Reference No:	2022/62/93868/W
Site Address:	477, New Hey Road, Salendine Nook, Huddersfield, HD3 3XG
Description:	Erection of single storey rear extension, rear dormer, formation of raised deck area, external alterations and dropped crossing
Recommending Officer:	Sam Jackman

DECISION – Conditional Full Permission

Officer Report – 2022/93868

Drawn No.
113

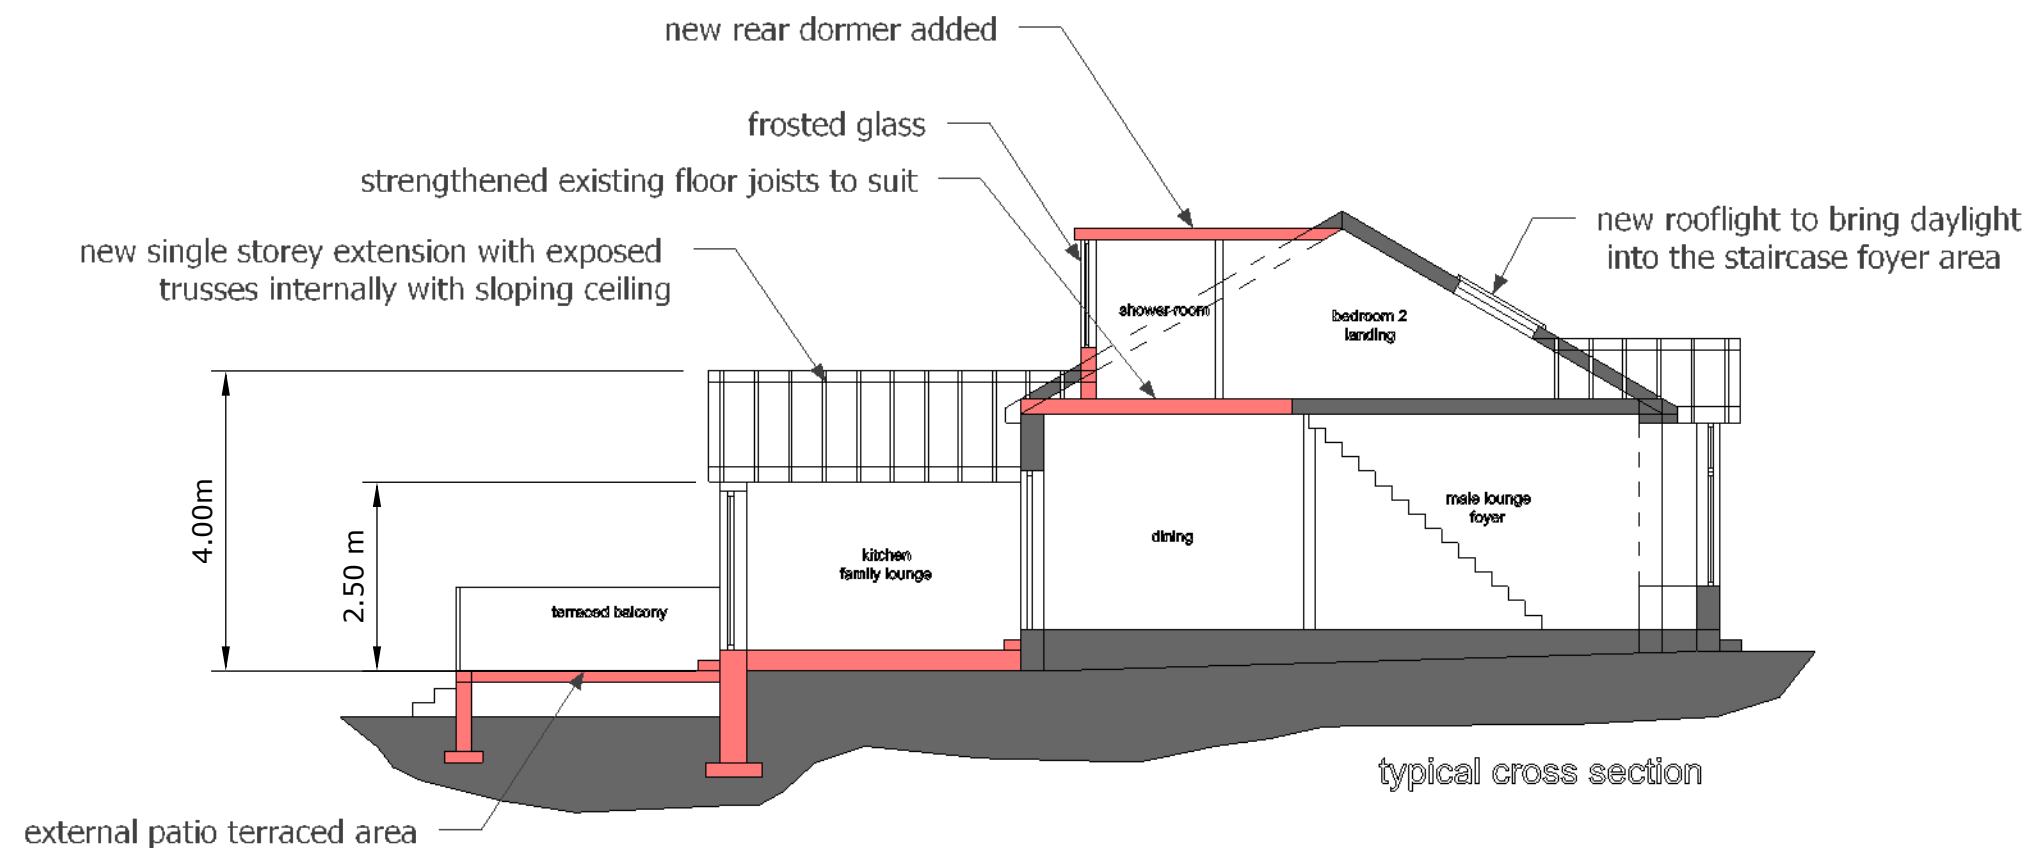
The proposal also includes a raised decking area to the rear of the property, projecting 3.5m by 10.5m by 0.575m high. 1.5m high fence is proposed along the boundary with No 475 New Hey Road.

With regards the raised decking the property currently has some decking area, which will be replaced along the shared boundary with No 475 where the existing screening is a 1.5m fence which wouldn't protect overlooking. This fence will remain at the existing height, however, due to the increased size of the decking, the use of the space will change, so that the seating area is directly to the rear of the property. The existing decking area will be now used for bin store. Regardless of this the relationship of the decking would be unchanged along the boundary with No. 475 and screening of this area is considered unnecessary.

Drawn No.
112

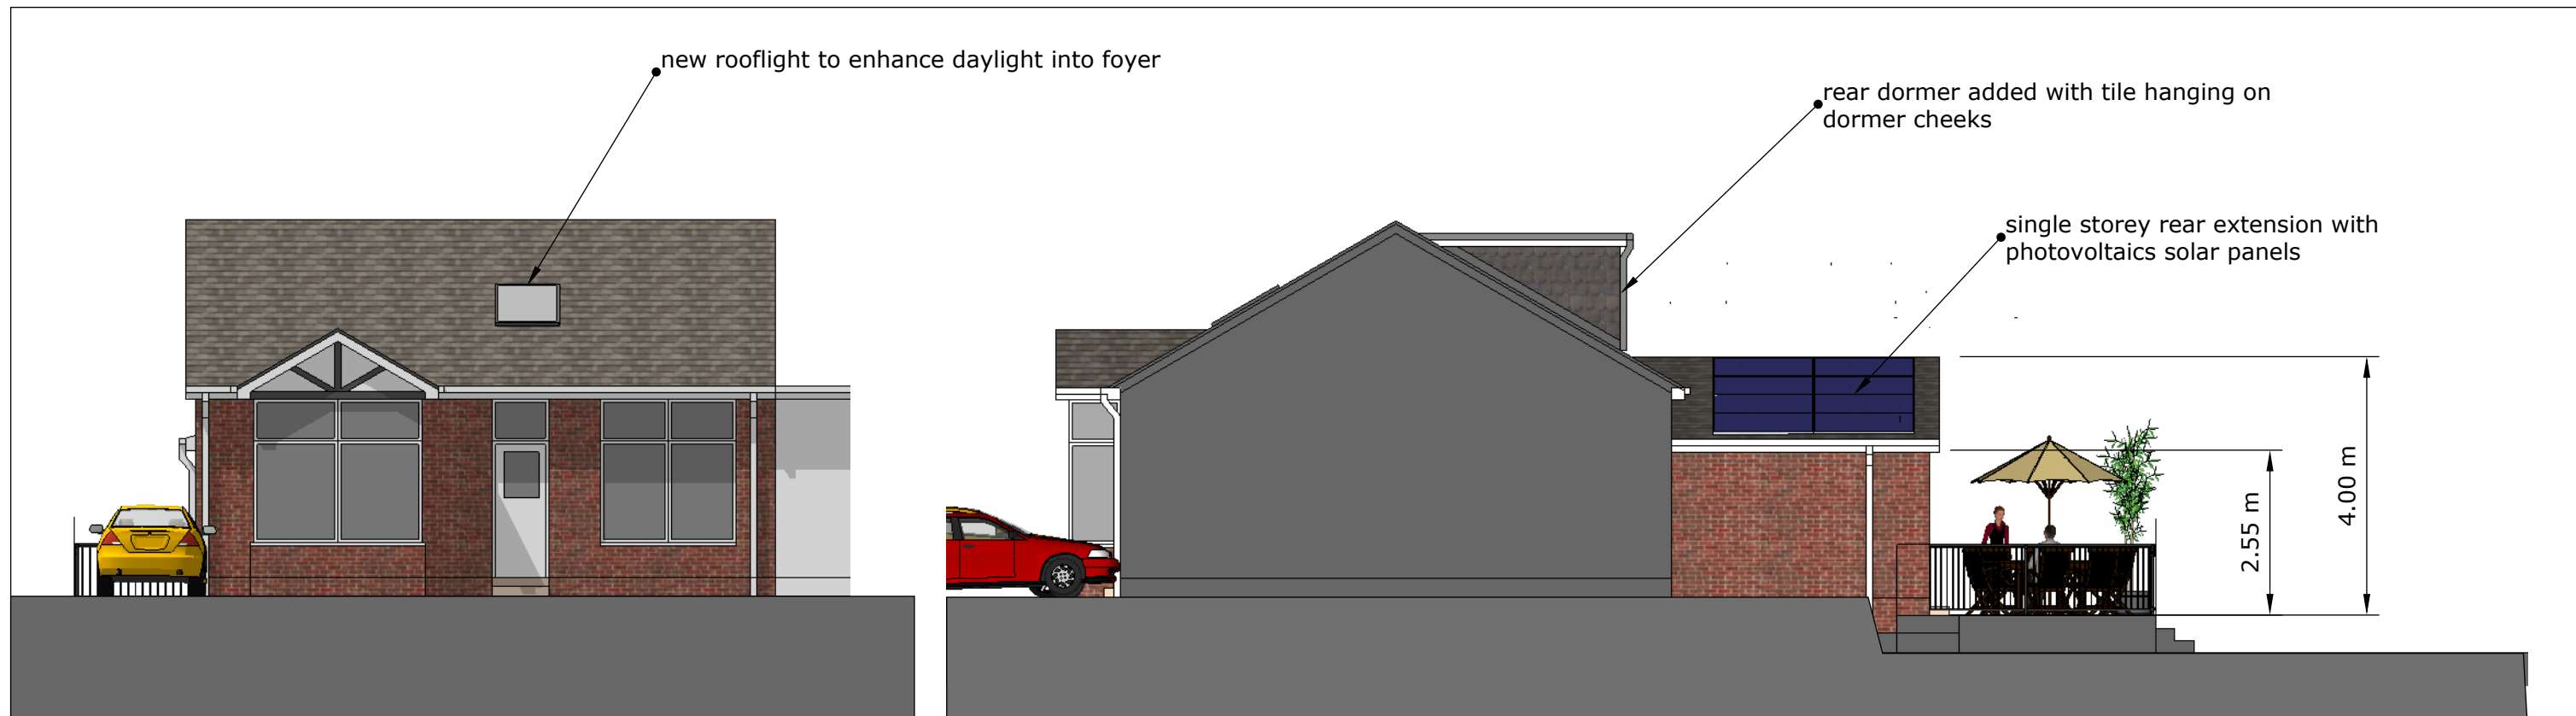
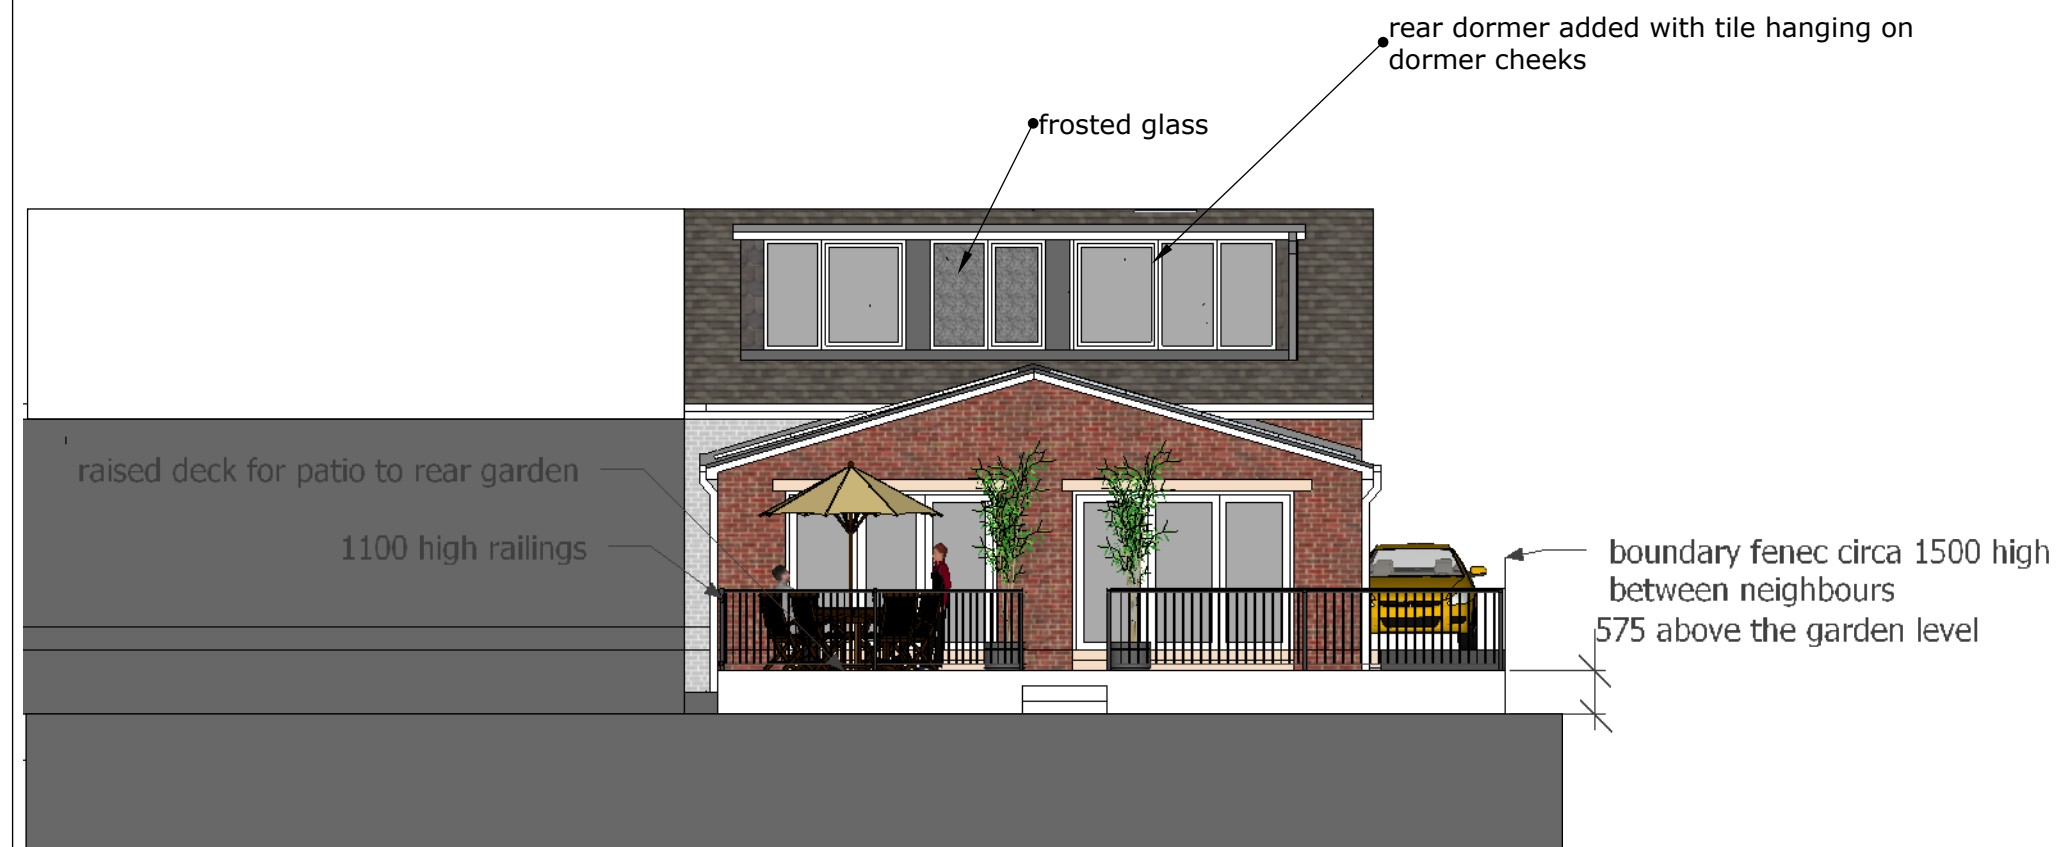
There would be limited views of the rear extension and dormer from the street, both from New Hey Road and Longwood Edge. Therefore, provided the rear dormers are cladded in dark hung tiles or similar to its neighbours, it is considered the extensions will have little impact on the street scene.

Section 5.25 goes onto state the design of dormer windows and roof extensions should reflect the character of the area, the surrounding buildings and the age, appearance and materials of the existing house. Ideally, dormers should be located to the rear of a house and should be as small as possible with a substantial area of the original roof retained. Where in this case the dormer is fairly large having an overall width of 7.3m, however, the dormer will be set in from the gable and shared party wall by 1m & 0.75m, in addition to be set down from the ridge by 0.2m. Furthermore, there are a couple of properties along New Hey Road which have had similar sizes dormers. Therefore, provided the dormer sides are dark hung tiles (condition 4) the dormer would have an acceptable design.

Where in this case the rear extension would fail points 3, 4 & 5, however, in this case consideration is given to the fact that the extension is similar to the attached neighbours proposed rear extension and dormer. Therefore, reducing its impact on this neighbour to an acceptable degree. Therefore, on balance the proposal would be acceptable with regards to the SPD.

4. Notwithstanding the submitted details, the rear dormer shall be clad in a suitable dark grey cladding or tile hung to match the existing roof and should be retained as such for the lifetime of the development.
